**Cloudy Bay, Gorse Avenue, Planning Ref K/23/25HH**

I am writing to object to the proposed extension of Cloudy Bay on the following grounds;

Drawing Name:
Proposed First Floor Plan

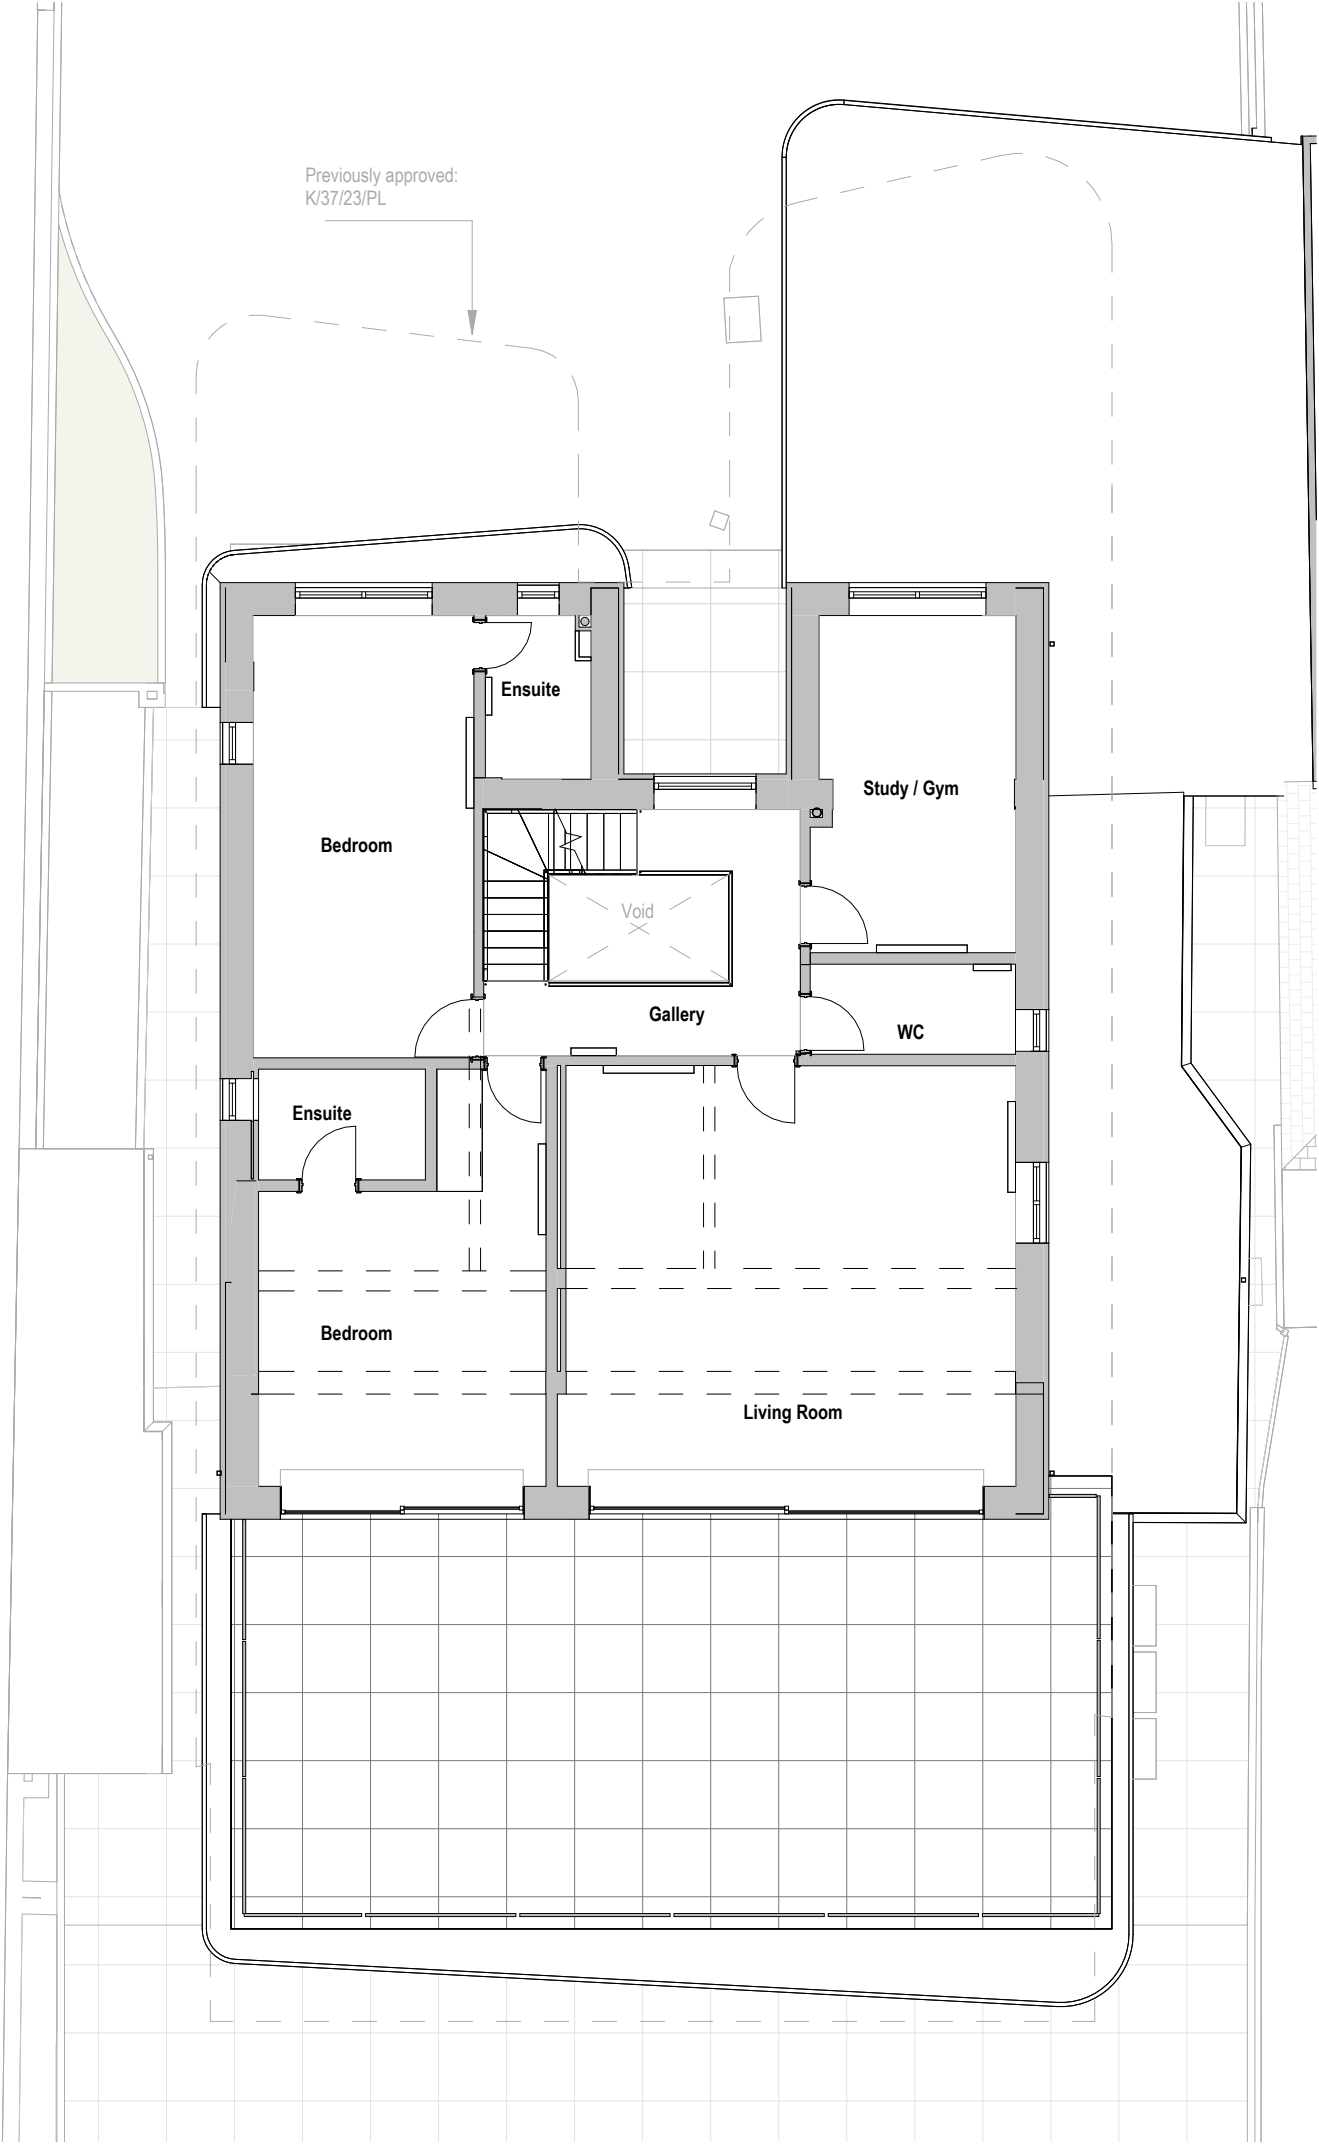
- **Overlooking and loss of amenity.** The proposals clearly illustrate the loss of amenity on Littlewood Deerswood main lounge windows by the use of the “45 degree rule”. Furthermore the extensive balconies although screened will have overlook our terrace and garden both in perception and in reality.
- **Overbearing nature and unneighbourly impact:** The Cloudy Bay plot is considerably narrower than adjacent plots and the increased height and blank nature of the east elevation will have a significant and unacceptably overbearing and overshadowing impact on both neighbours.
- **Planning Notice:** There was no planning notice visible on Kingston Gorse outside or adjacent the property, which is a contravention of the planning requirement of Arun District Council.

**Proposed Site Plan**

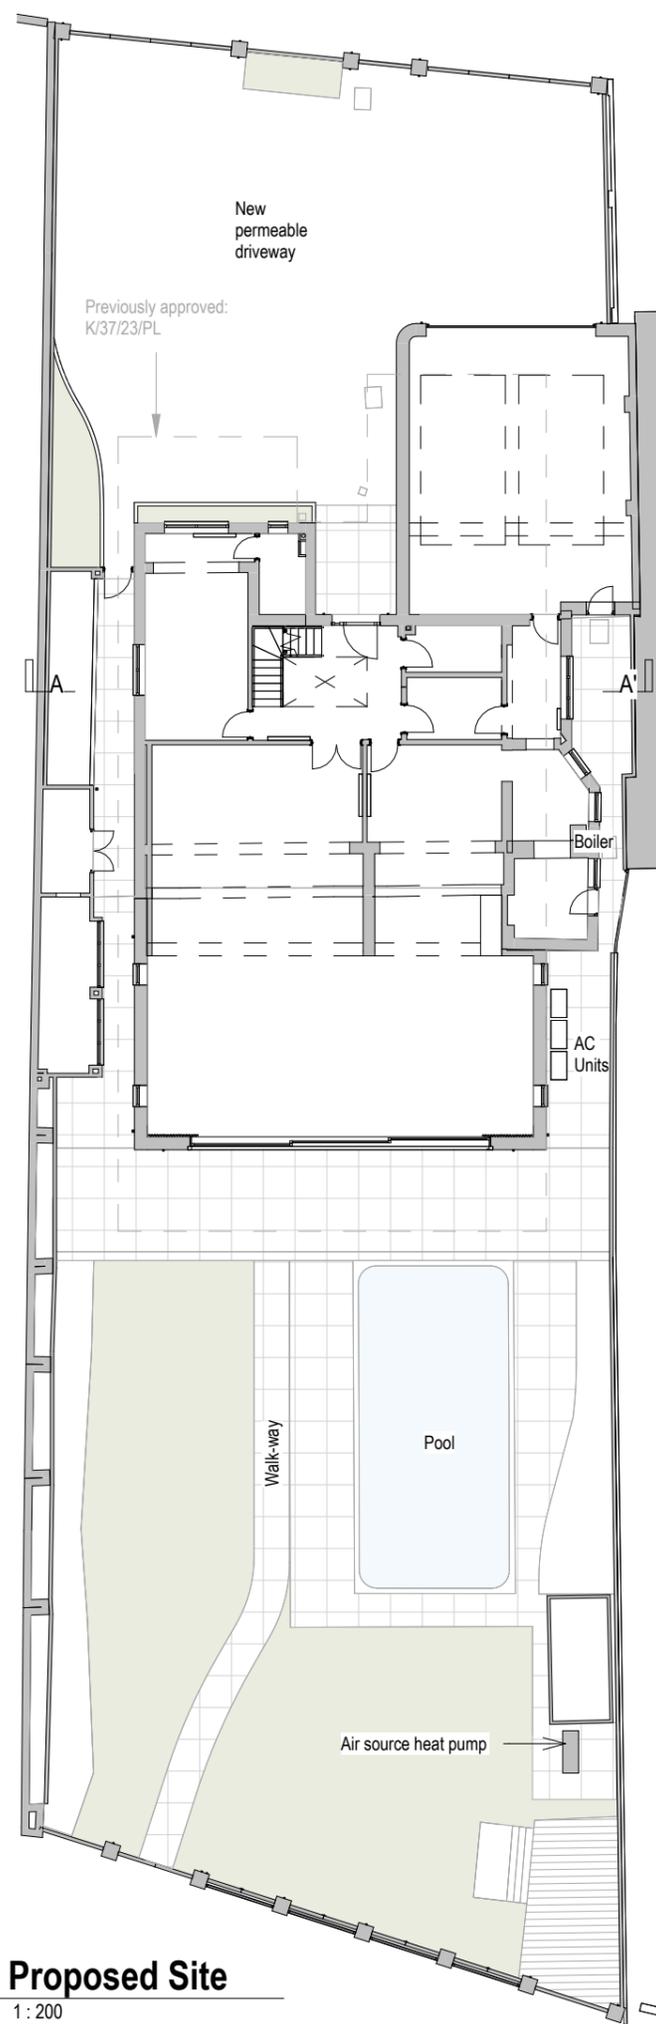
- **Siting of proposed development:** The proposal is located considerably further south of neighbouring properties Little Deerswood and Sandy Lodge. The proposal will have a detrimental effect on the light and aspect of Little Deerswood. This will be most evident from the first floor bedroom window, pictured below, which will suffer a considerable loss of light. The present room is our son's bedroom. If the plans were to be granted permission, a 'tunnel view' light of the sea will be created due to the first and second floor extension and balcony screening which is proposed. The loss of light will be substantial and highly detrimental.

In summary the proposed extension due to its height, bulk and location on the plot would be detrimental to the residential amenities of the adjoining property to the east. It is in conflict with Arun Local Plan policies DM1 & DM4 and Policy KPNP 7 of Kingston Neighbourhood Plan. Ultimately, the local plan is in existence to protect the rights of residents seeking to develop and residents seeking to protect their homes. If the Council’s own policies are not enforced on residents’ behalf, it calls into question why we have a plan at all and overall confidence in the Council to act to protect us, the residents. I look forward to a recommendation that this permission be turned down.

Proposed South and West Elevations

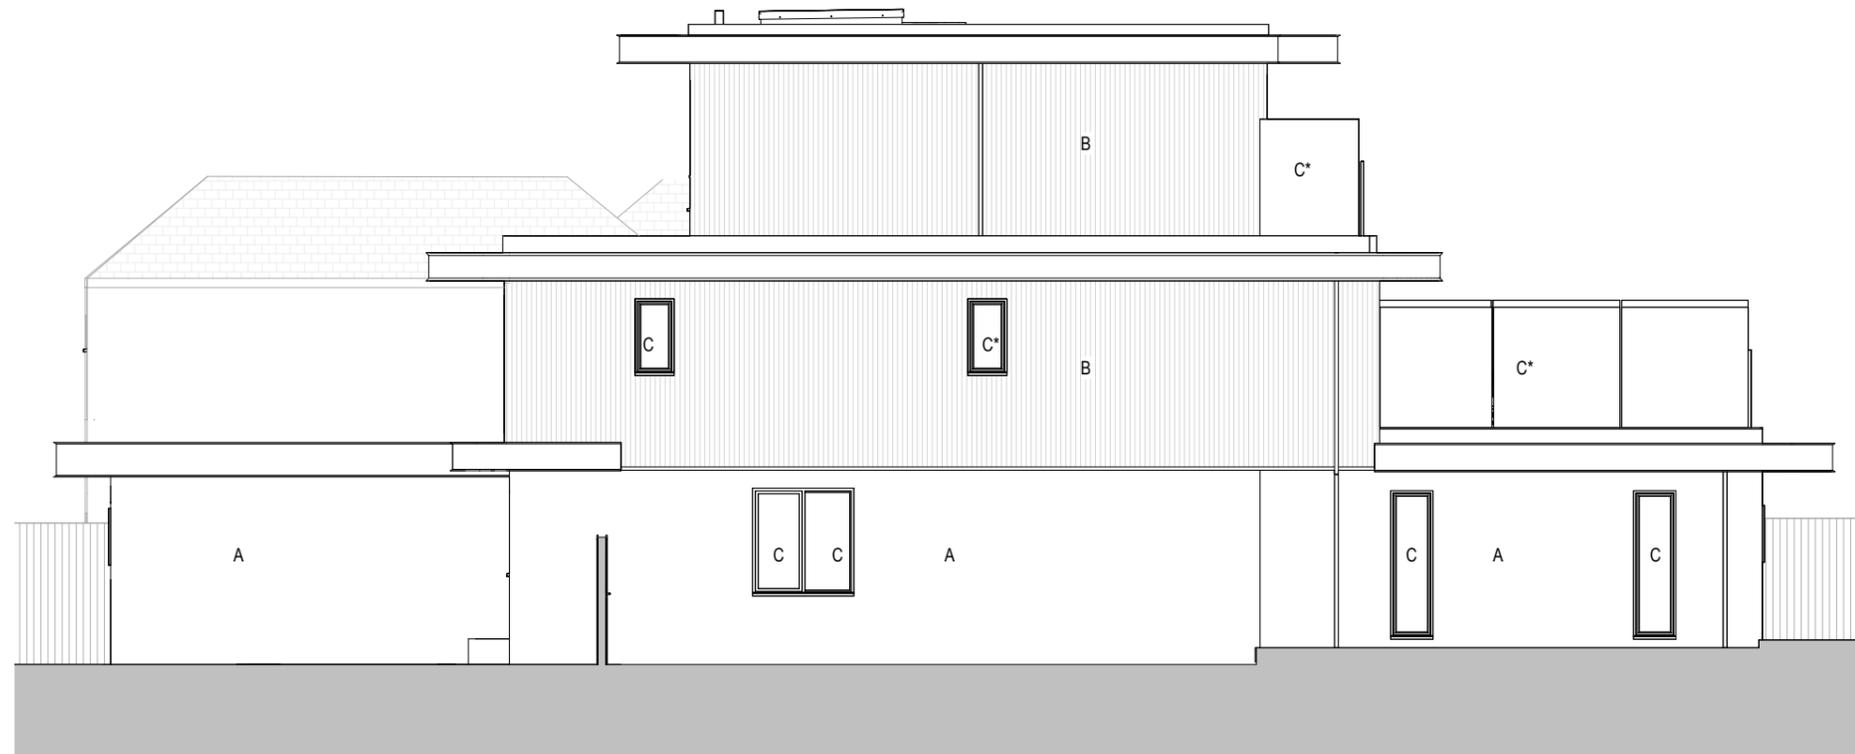
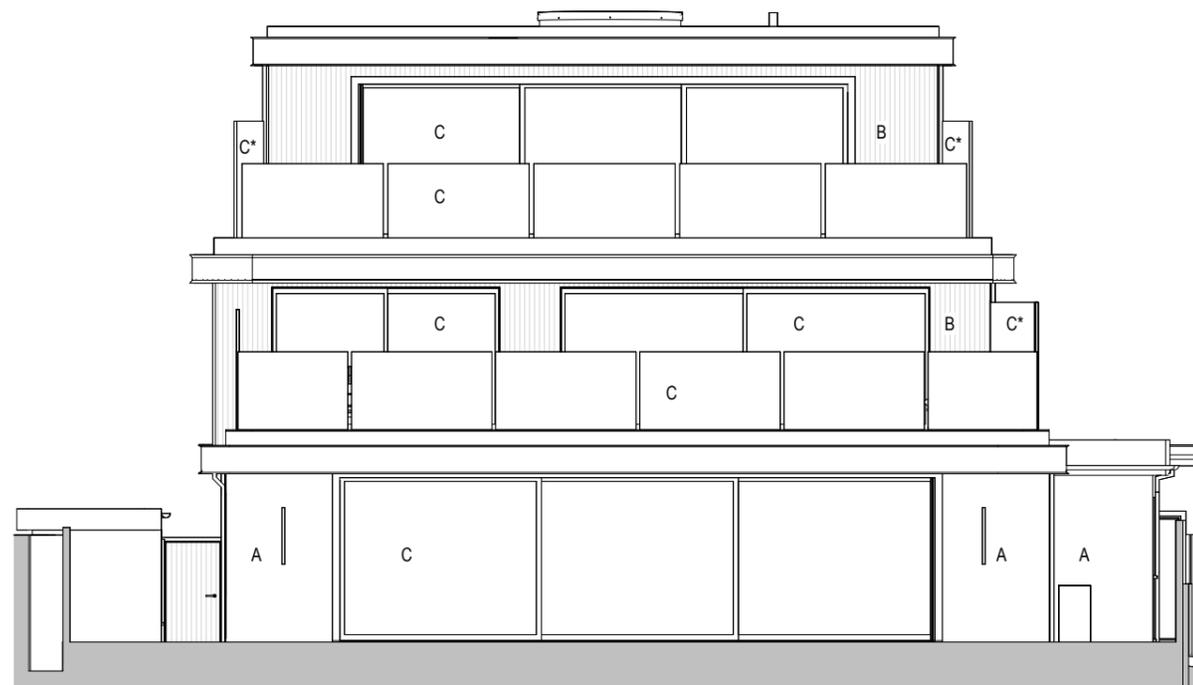
- **Policy DM1 & DM4: Extensions and Alterations to Dwellings.** The policies require extensions to be subordinate and respectful of the host dwelling. As an extension it should be subservient to the existing house, not obliterating it as this scheme clearly does.

It is clear from the proposals that the existing building is masked by the extensions to the north, south and the second storey. This is an attempt to develop the property in a similar manner to the extent application K/37/23/PL. However, this is not a new build replacement development and in accordance with Policy DM4 any extension should be design to compliment the existing building. With an existing pitch roof, additional rooms should be incorporated in the roof space for instance.
